From: Mark Berry
Sent: 10 April 2017 13:39
To: Matthew Woodward
Cc: Highways DevelopmentControl; Steven Sampson
Subject: 2017/90207 Huddersfield Road Thongsbridge

Highways initial comments are as follows:

This is an outline planning application with access the only matter to be considered.

Project	Proposed B1 and Light Industrial Units at Thongsbridge Mills, Thongsbridge		
Client	Mr S Marsden c/o RHPC, Bowers Mill, Branch Road, Barkisland		
Dwg Title	Indicative Layout	Rev.	A
Scale	1: 500 @ A1		
Date	Feb 2017

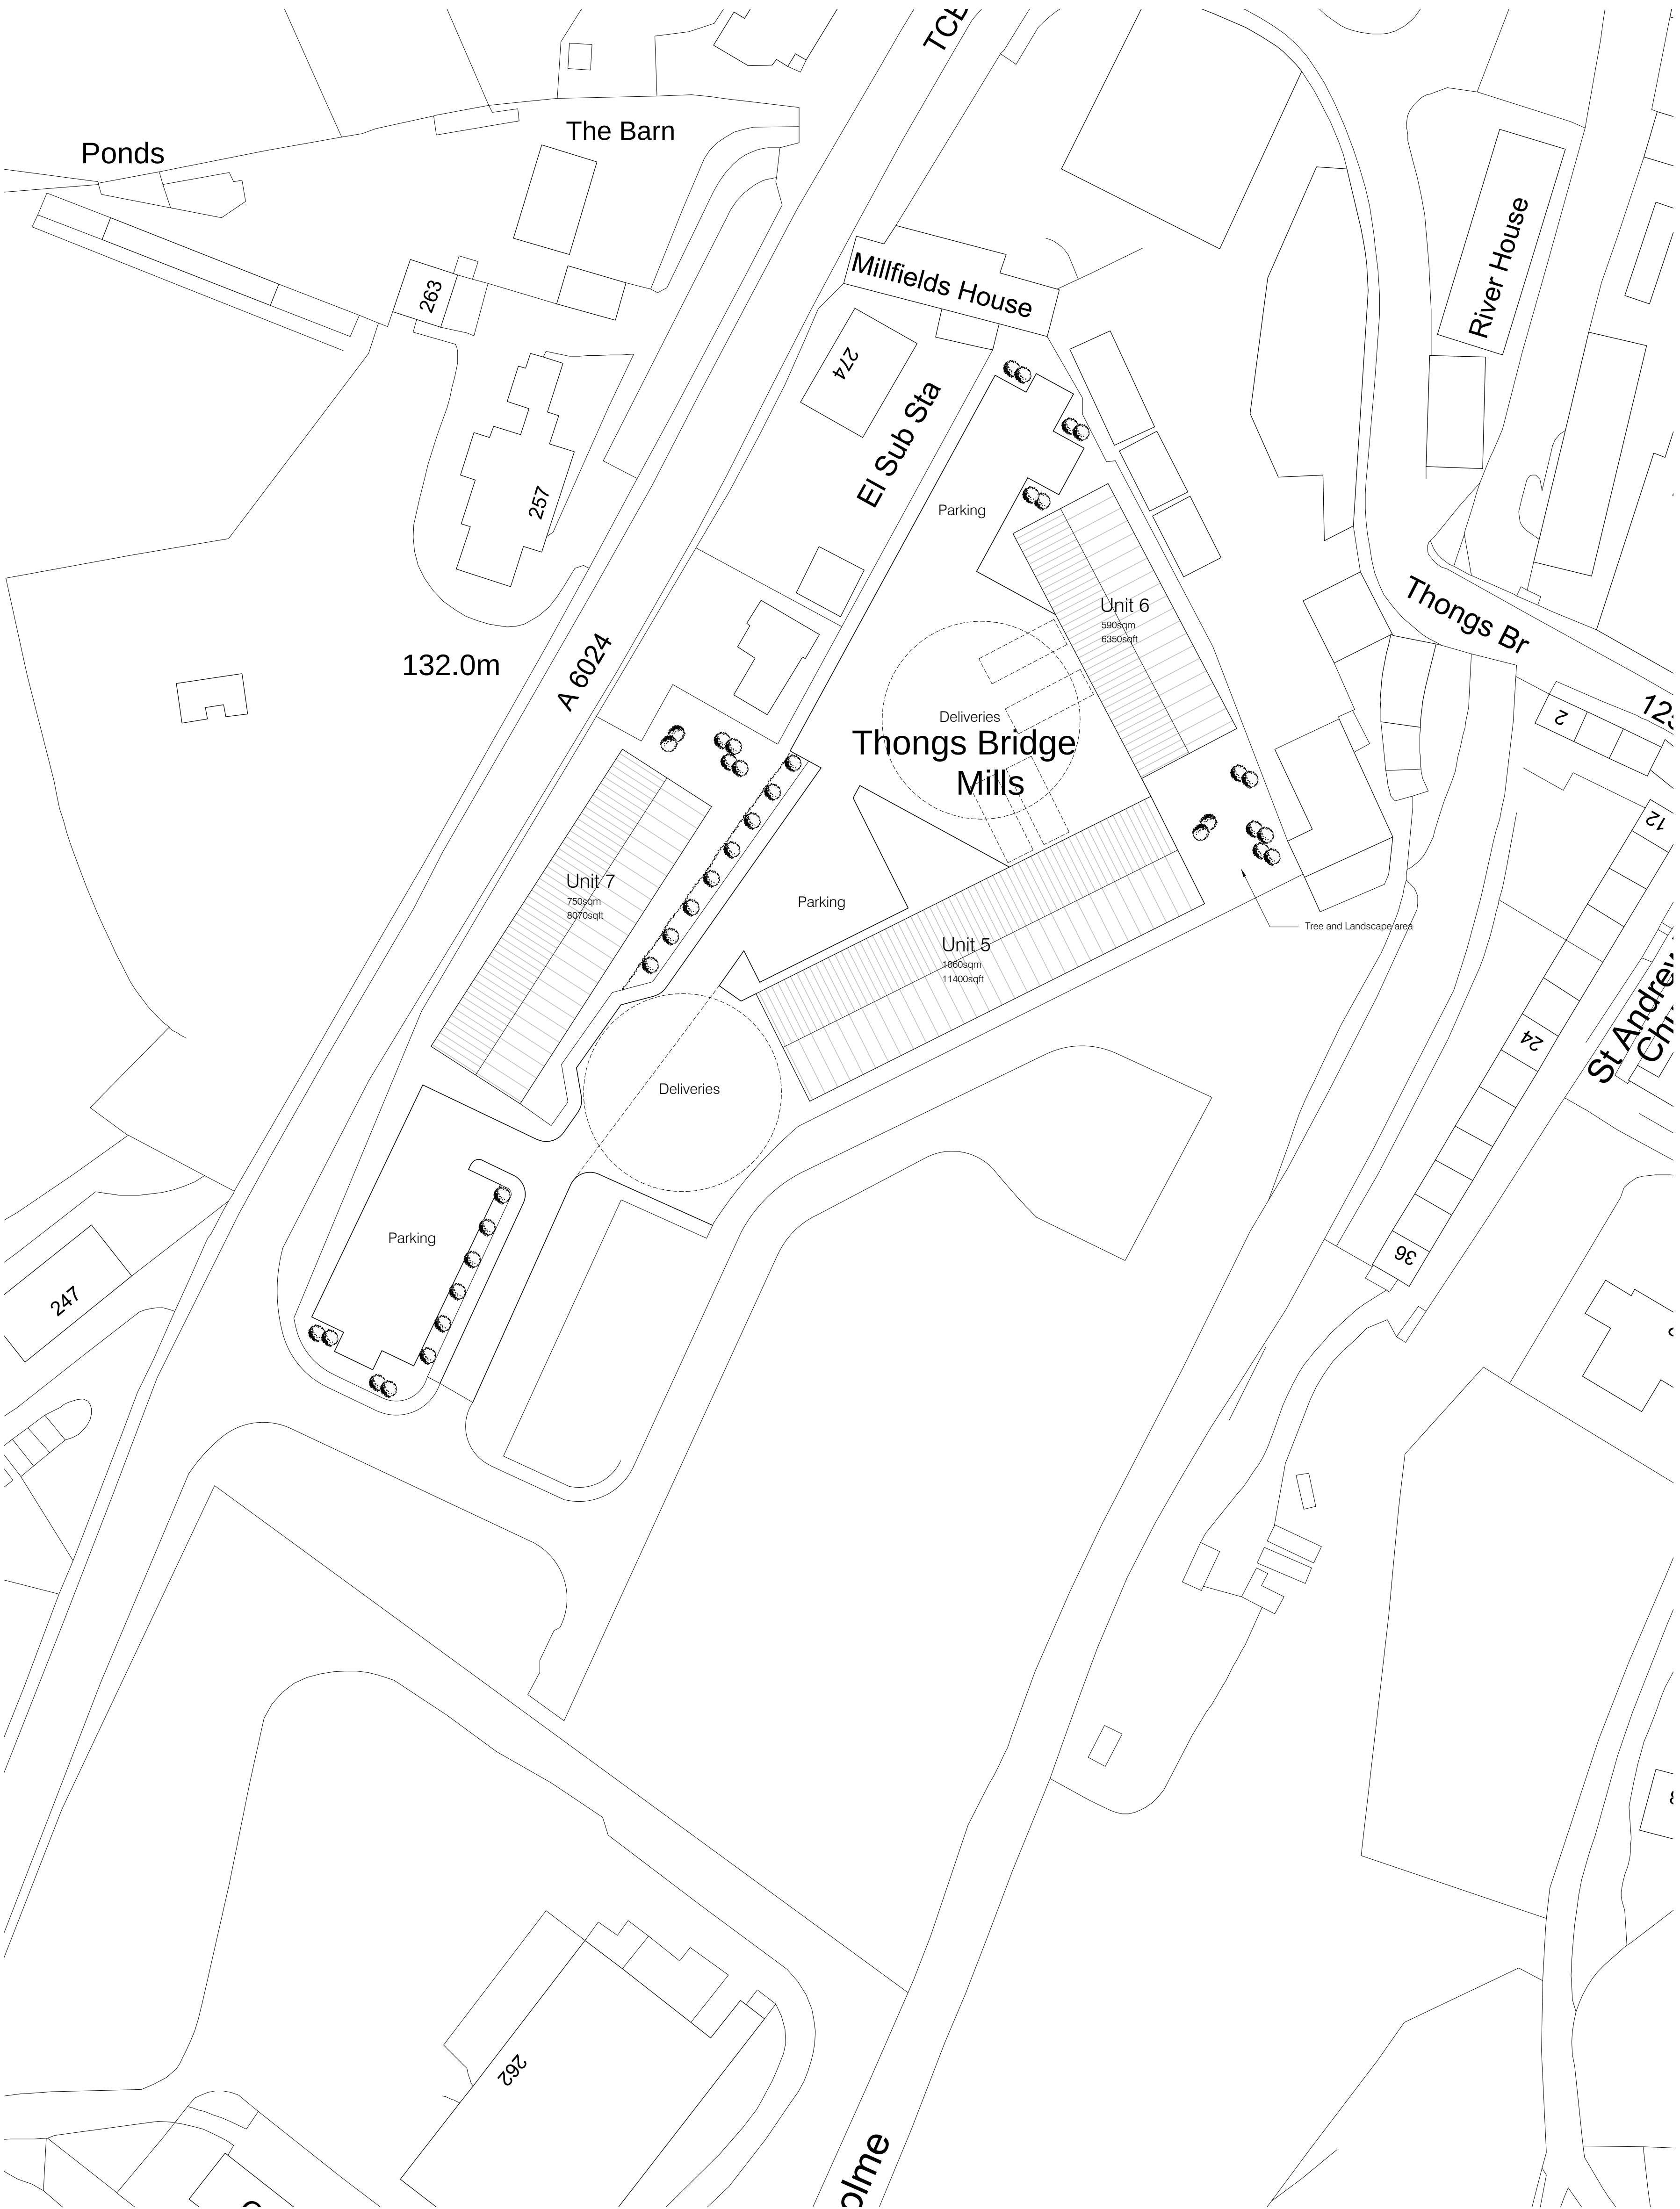
No parking numbers are provided and the layout is considered to be indicative. Without further assessment/justification highways consider that parking in accordance with recommended standards should be provided.

The internal access road contains an existing spur which will be used to access the site.

This spur was originally designed for the proposed residential use and the width and kerb radii are inadequate for industrial use. Widening this road and increasing the kerb radii moves this road closer to Huddersfield Road.

PROPOSED ACCESS FROM BOTH DIRECTIONS
SCALE: 1:250

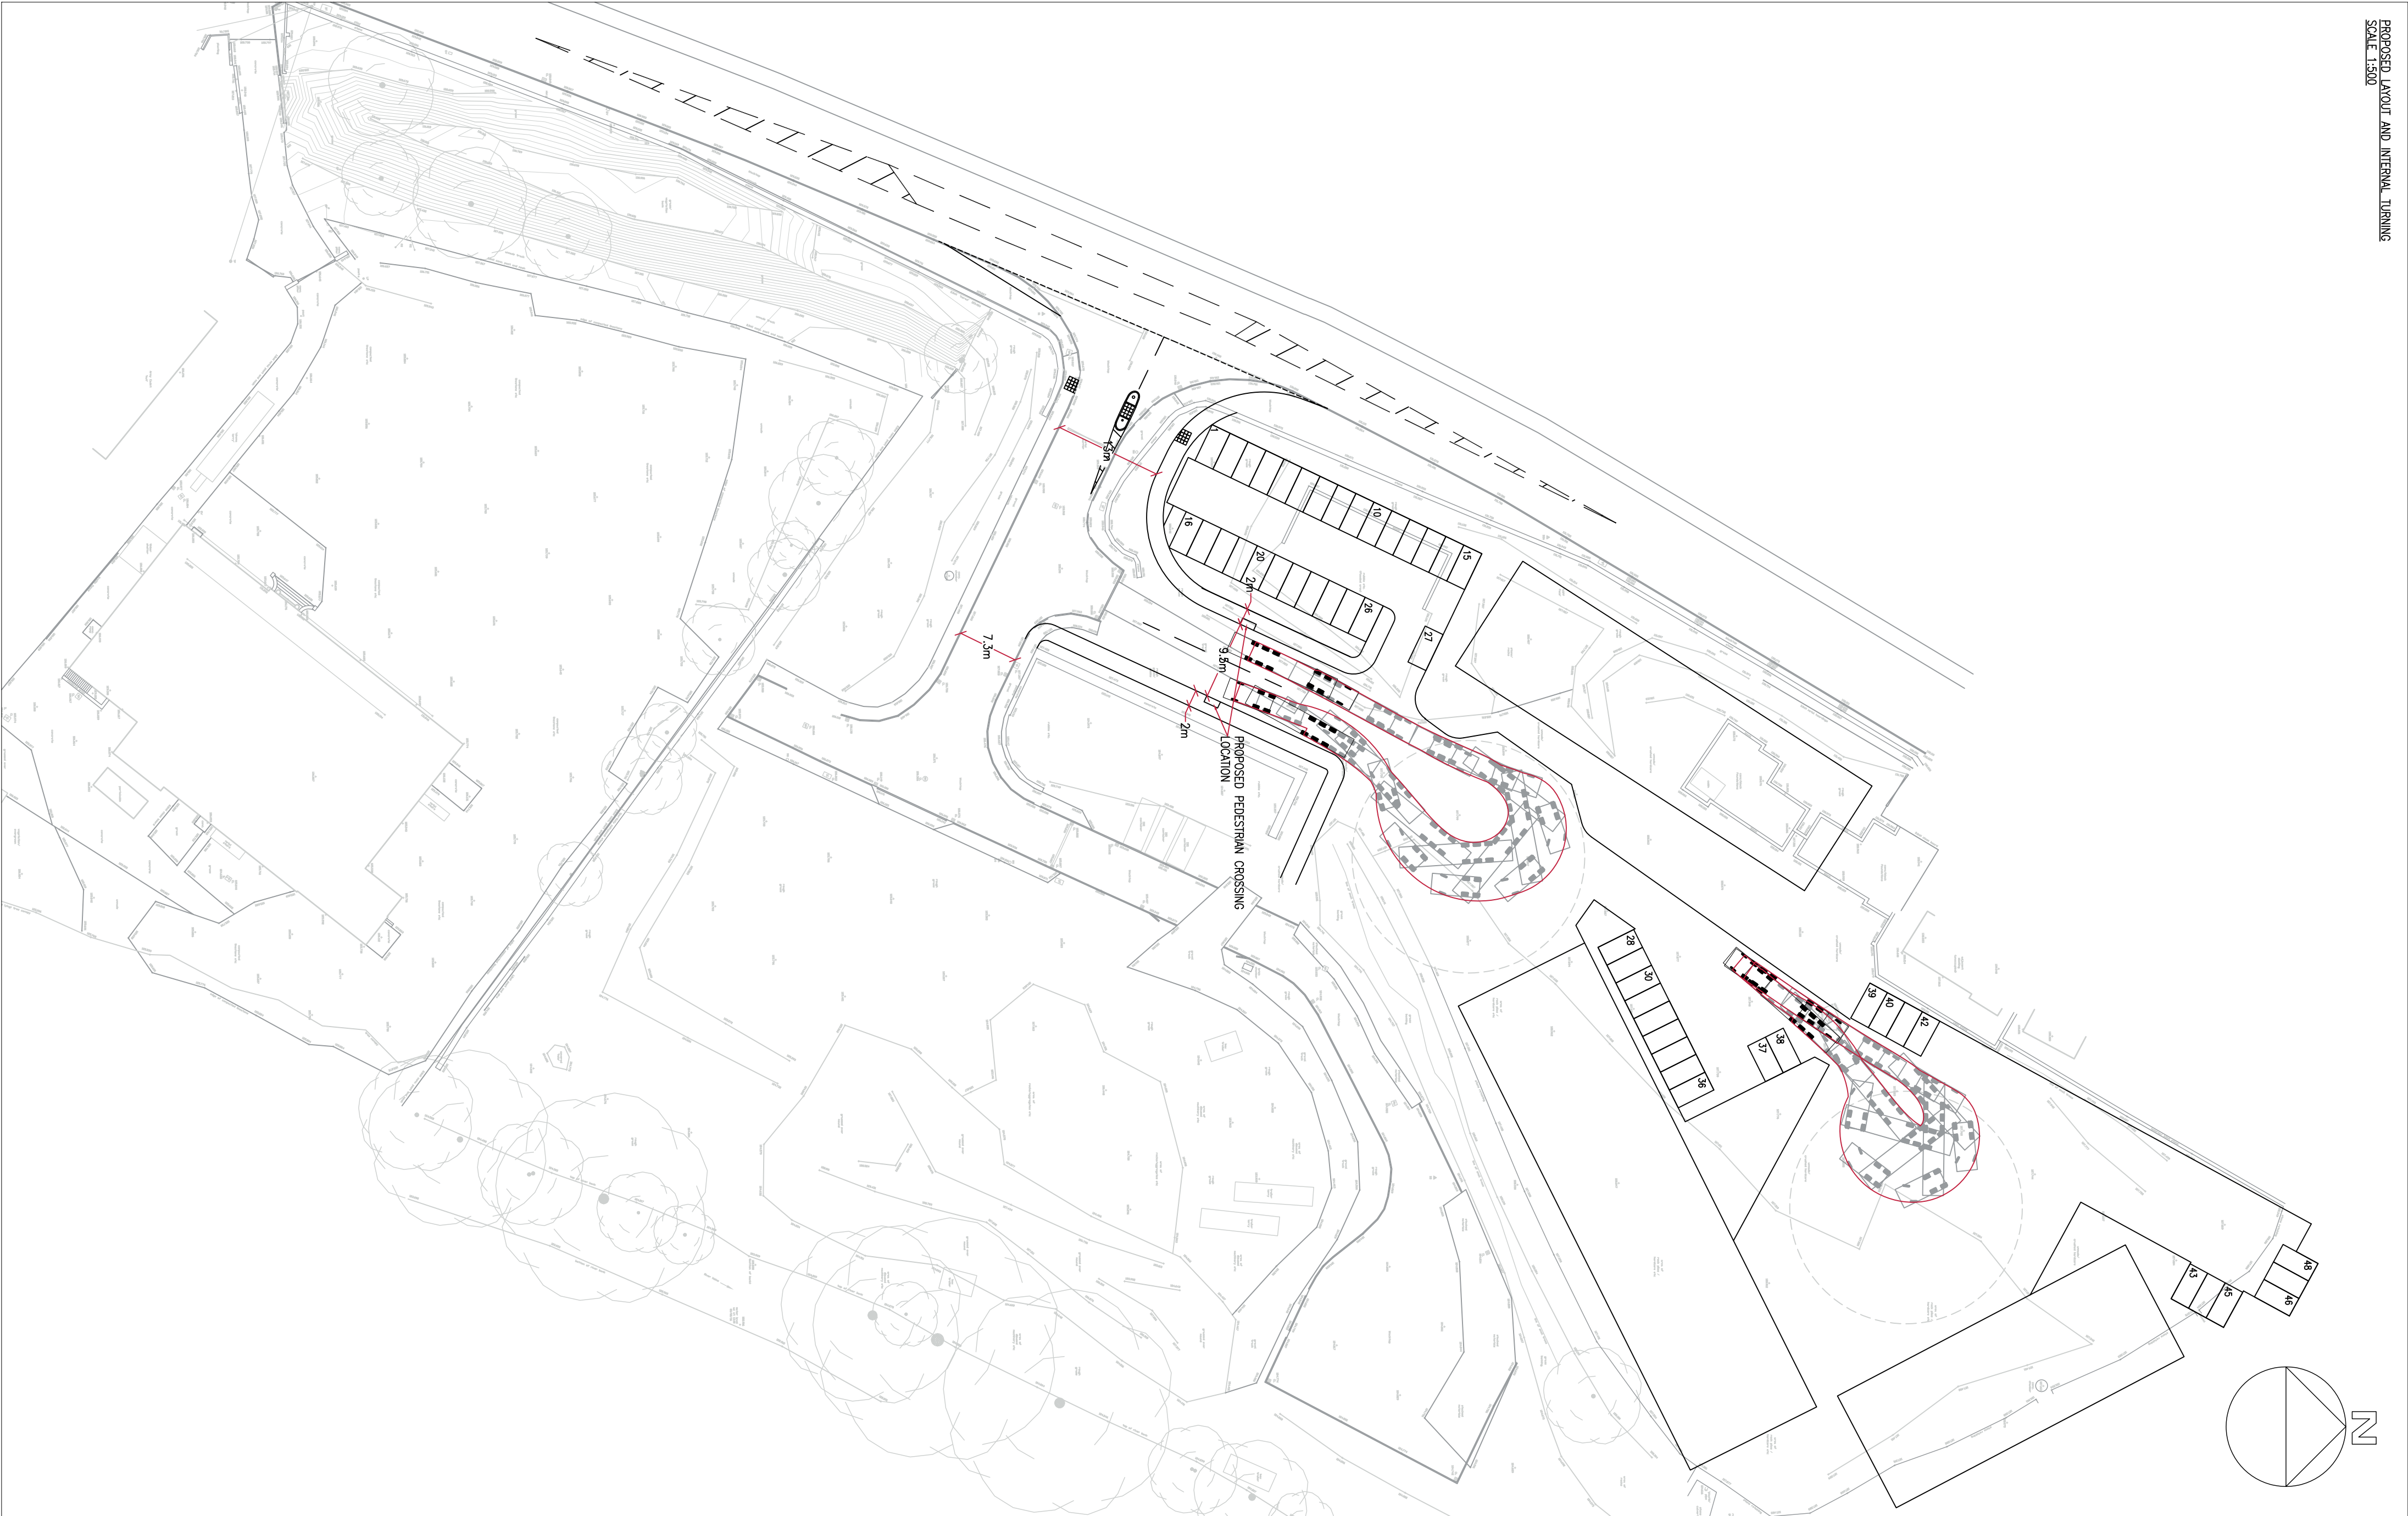
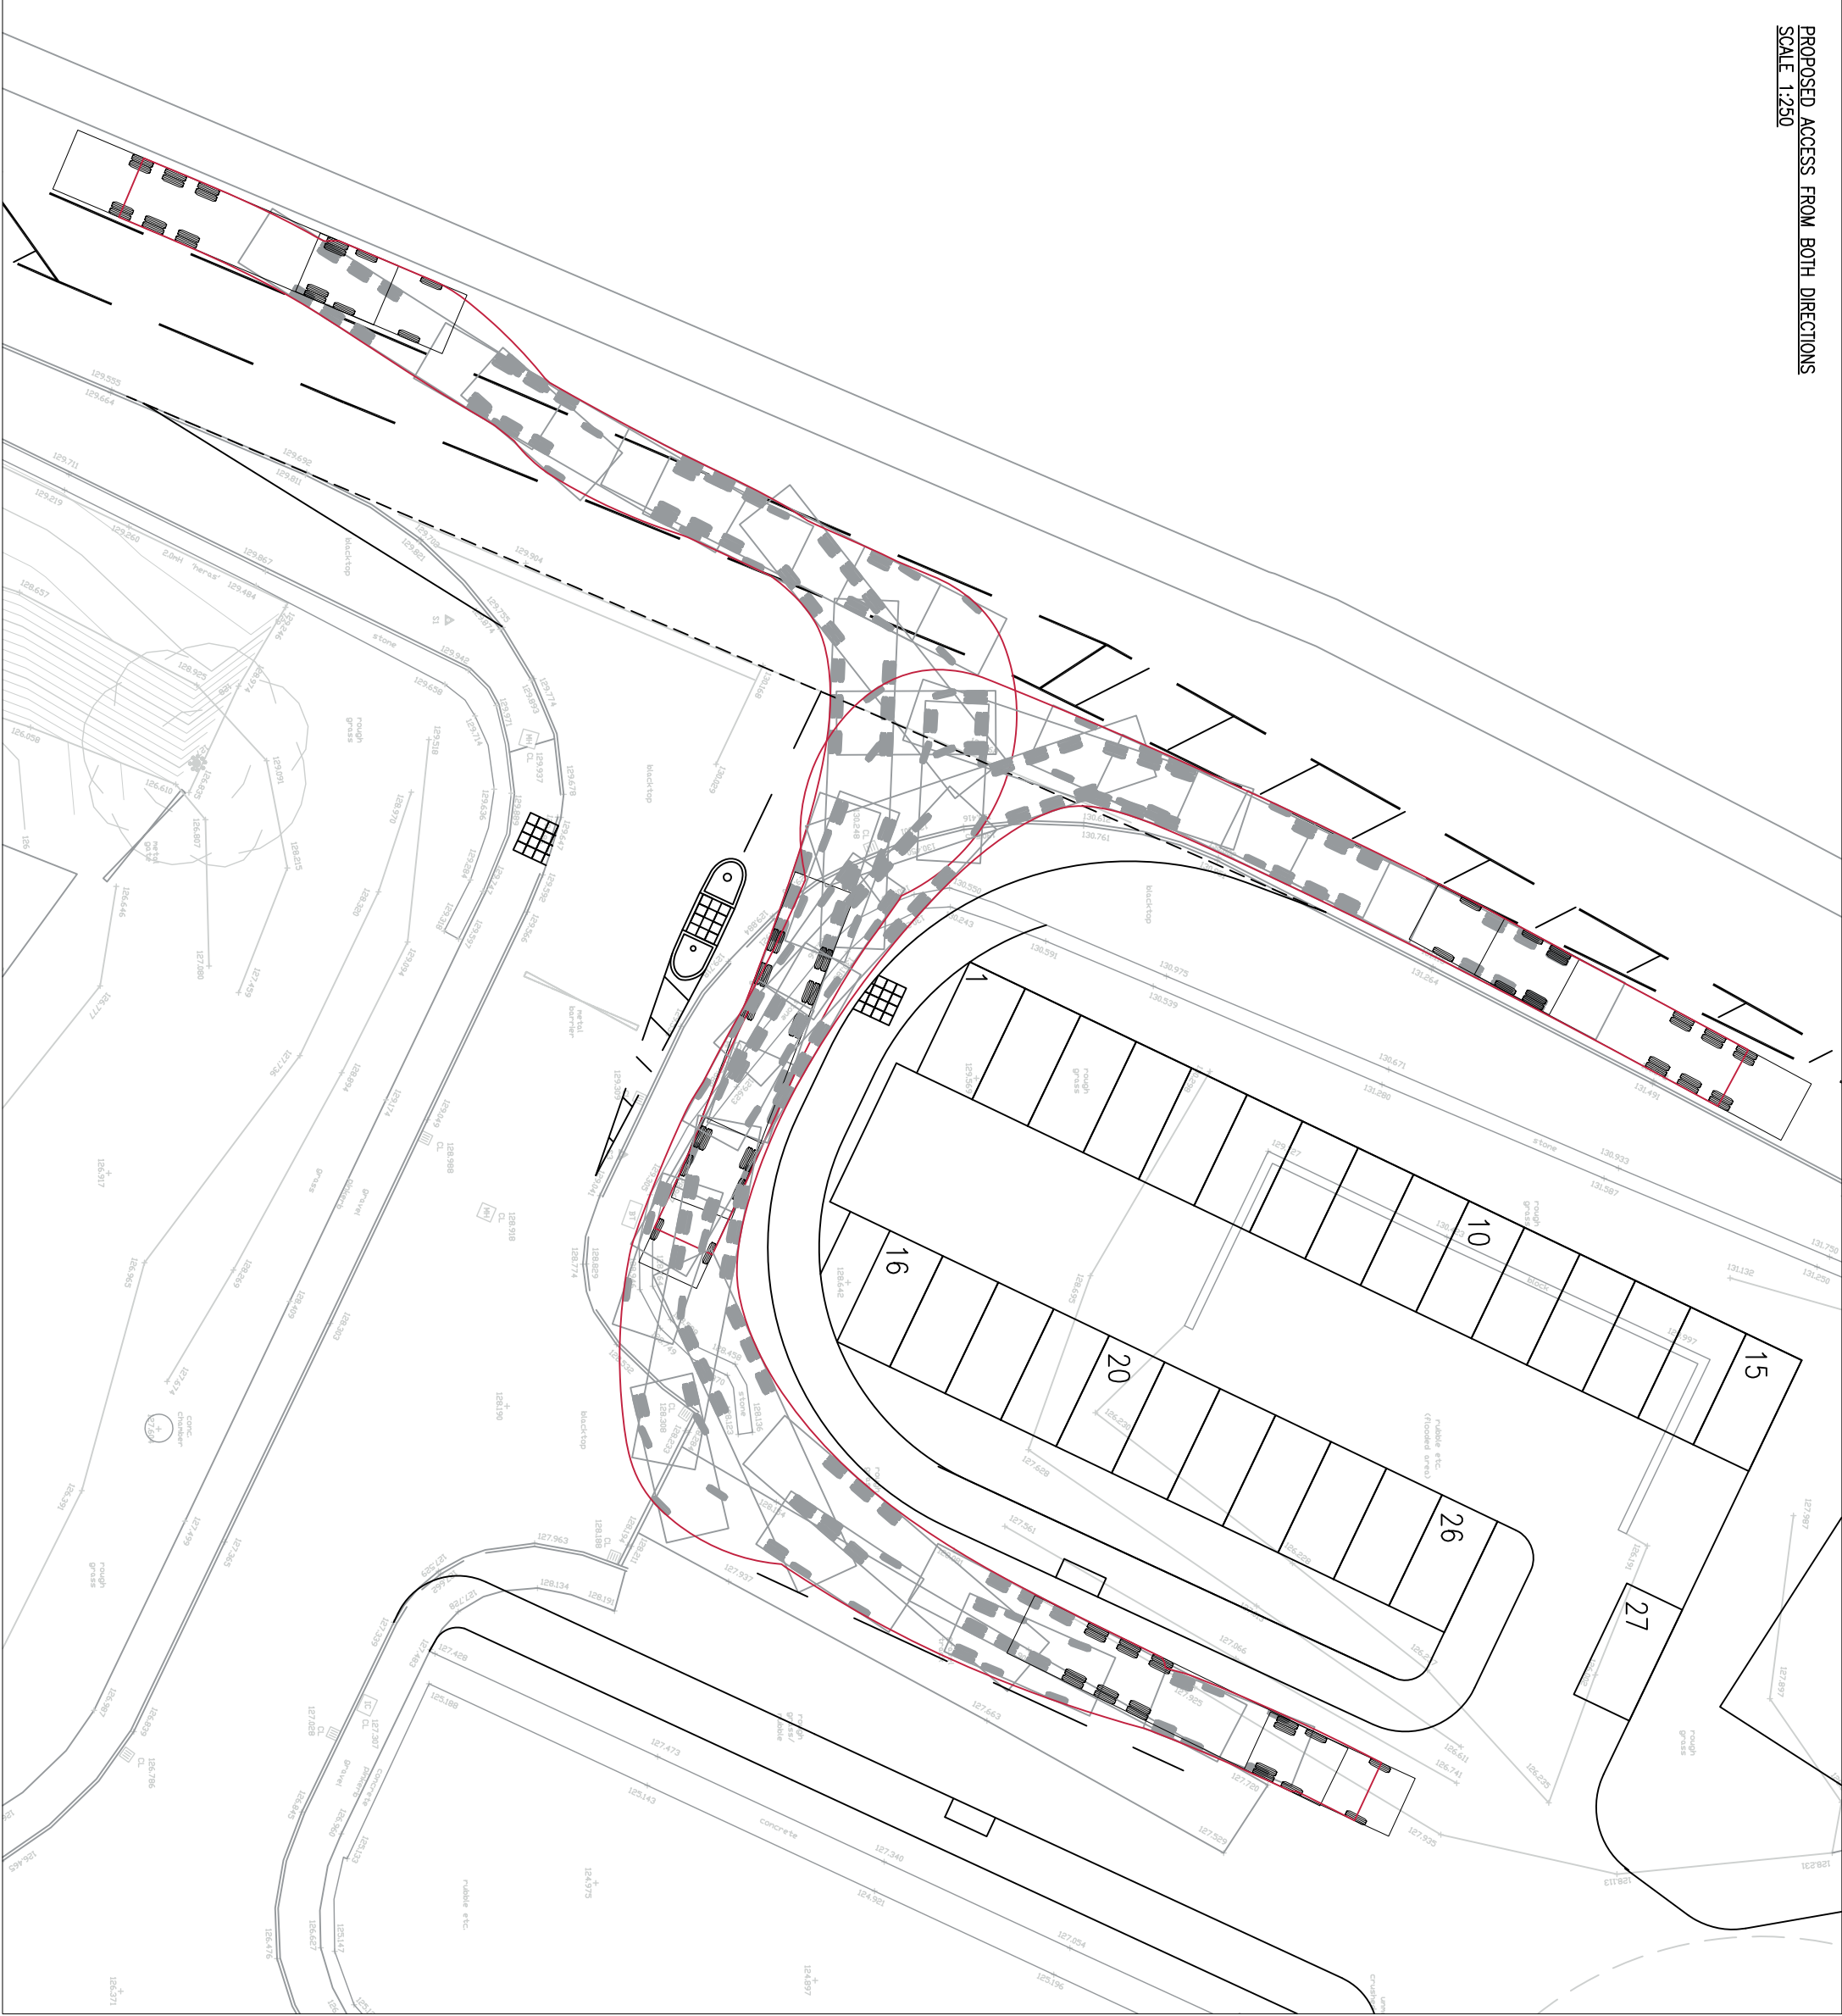
The applicants should be asked to demonstrate by means of swept paths that a 16.5 metre articulated vehicle can enter the site from Huddersfield Road in both directions and turn into and out of the proposed development site without over running adjacent carriageway.
